**To:** Lesley Collins, City of Ottawa Planning Department  
**From:** Carl Bray, Bray Heritage  
**Date:** Tuesday, March 3, 2015  
**RE:** 173 Huntmar Road: response to City comments and revised site plan

I have reviewed your comments, and those of other City staff, as provided in the letter of September 9, 2014 to Ms. Julie Carrara of FOTENN planning consultants. She has since added comments from the City of Ottawa Urban Design Review Committee. The intent of this memo is to address concerns the City may have as to the ways in which the existing building is being integrated within the proposed development. The following comments are based on a revised site plan (February 26, 2015), prepared for Amazon Properties by FOTENN.

**DRAWING**  
**SITE PLAN**

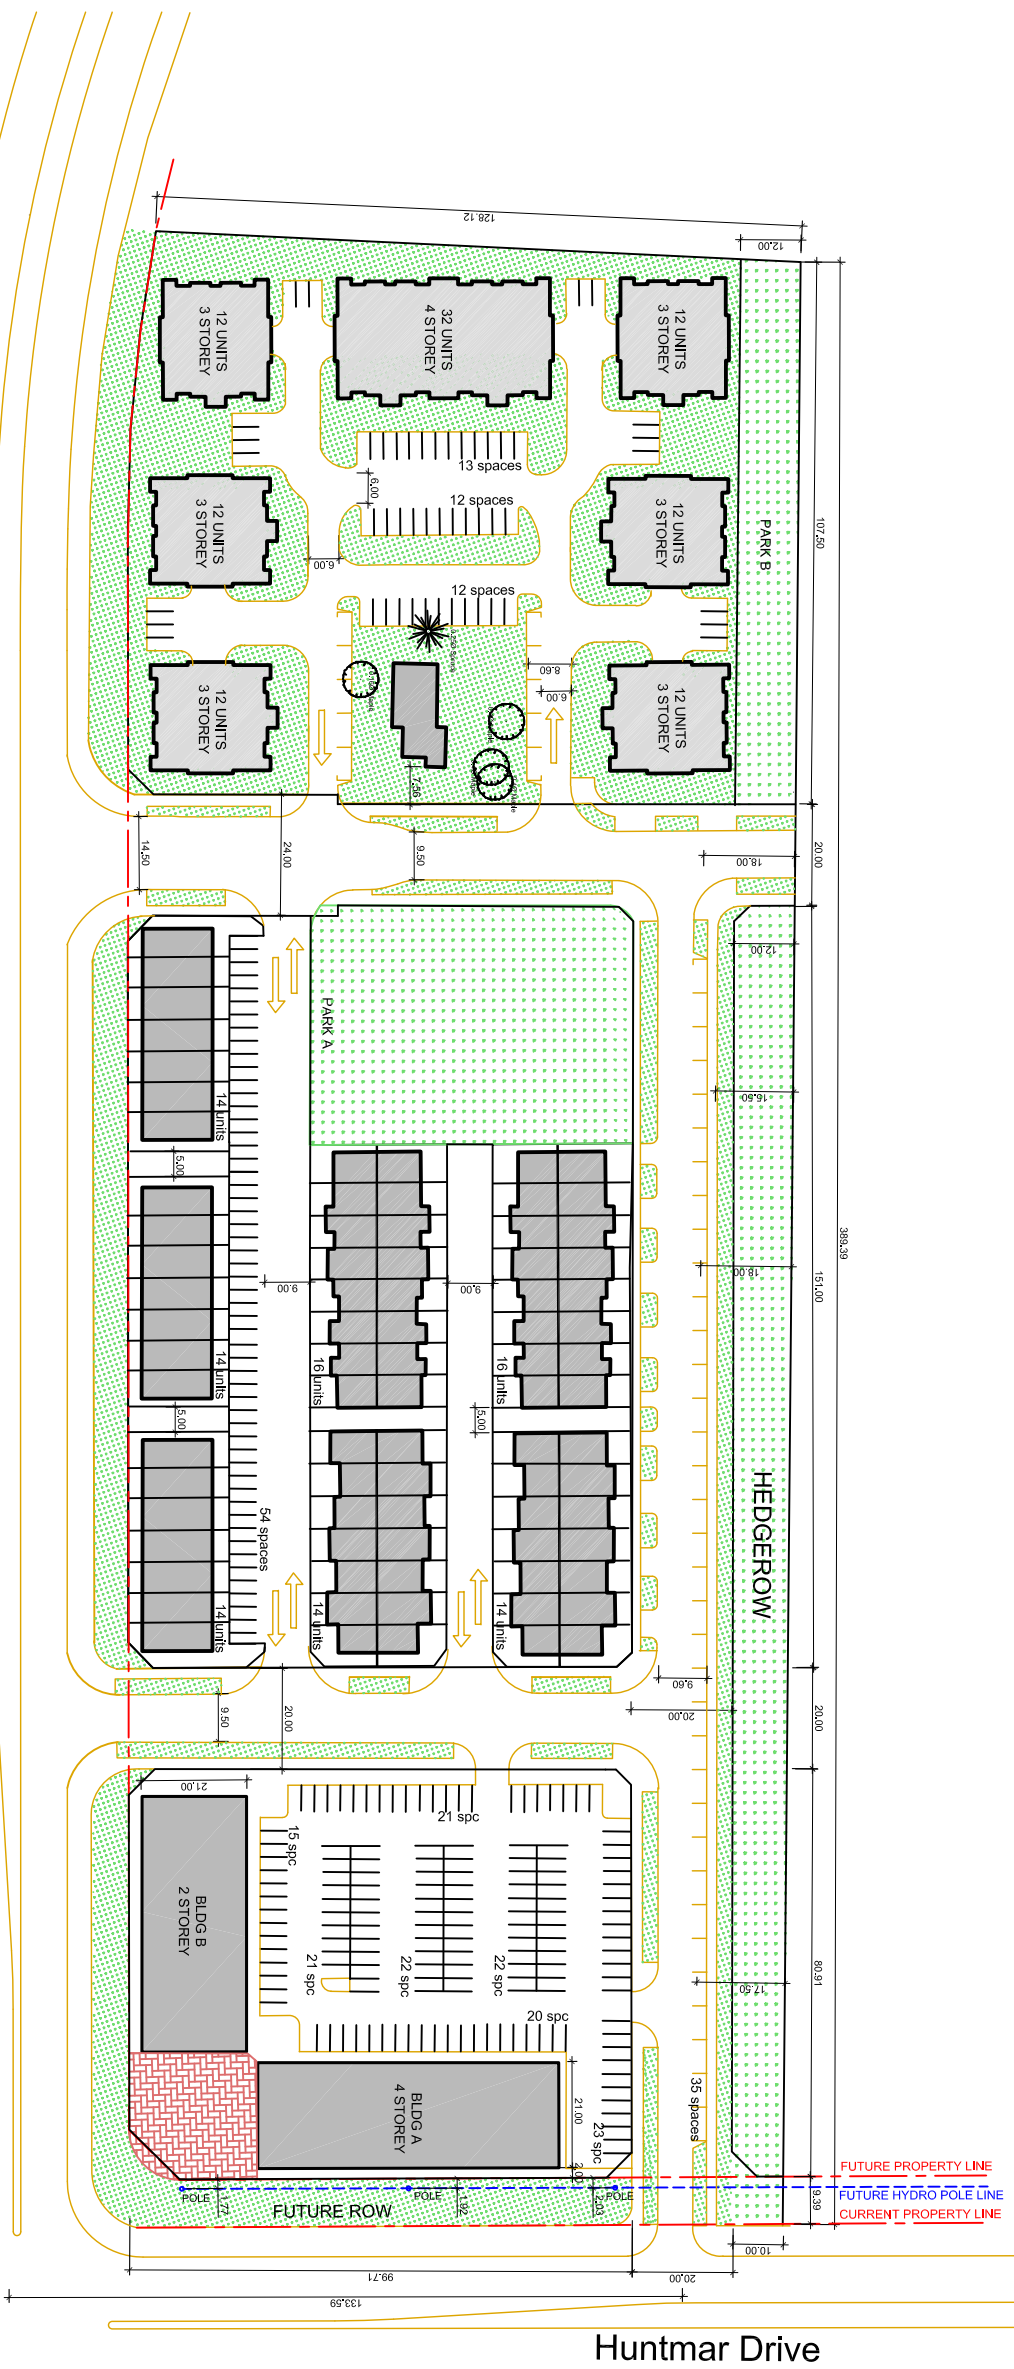
Comments from Development Review as well as from you indicate that the previous site plans did not adequately address the relationship of the farmhouse to the surrounding development. The revised site plan addresses this issue by:

The revised site plan permits retention of the existing trees in the immediate vicinity of the farmhouse. The mature apple trees, as well as the maples and spruces north and west of the house, are important in establishing the landscape context for the house. Mature, healthy trees in the vicinity of the farmhouse have been identified by the project team and are indicated on the revised site plan. Efforts should be made to conserve existing trees in front of the house to the east via retention within the right-of-way of the proposed connector public road. Opportunities also exist for retention of mature specimens in the proposed linear parkland along the northern property line.

As for the coniferous screen along the north property line ("hedgerow"), it has been retained as part of a linear buffer along the northern edge of the proposed main access public road. Specimens of the mature butternuts along the south boundary may be retained if the setback permits. The deciduous row flanking the south side of the existing entrance drive is unlikely to be suitable for retention but is less continuous, and appears to be in declining condition, compared to the coniferous row.

The revised site plan provides an improved arrival sequence into the site from Huntmar Drive. The proposed public east-west street follows the alignment of the existing access drive and thus replicates much of the arrival sequence that currently exists. While the existing farmhouse does not close a vista, as one moves along the entrance drive to the west, the farmhouse and park gradually come into view past the proposed development and are fully visible at the intersection with the proposed north-south street. This arrangement provides a somewhat comparable sense of discovery to that offered by the existing setting.

- expanding the lot upon which the farmhouse is situated
- moving the on-site parking to the edges of this lot
- placing the farmhouse in a residential precinct flanked by narrow access driveways
- removing the existing rear addition to provide space for any future additions
- establishing a park opposite the farmhouse lot, to the east across a public road

These changes will permit the retention of more of the existing trees adjacent to the farmhouse (see below) and reflect the historical relationship of the farm complex to the surrounding farmland. The complex was situated on higher ground – a ridge of glacial deposits unsuited to agriculture— that stood above the clay plain which, when drained, supported farming. Retaining the farmhouse in situ, on a larger lot, and with the former location of fields replaced by a park to the east opposite the ridge, reinforces this historical relationship.
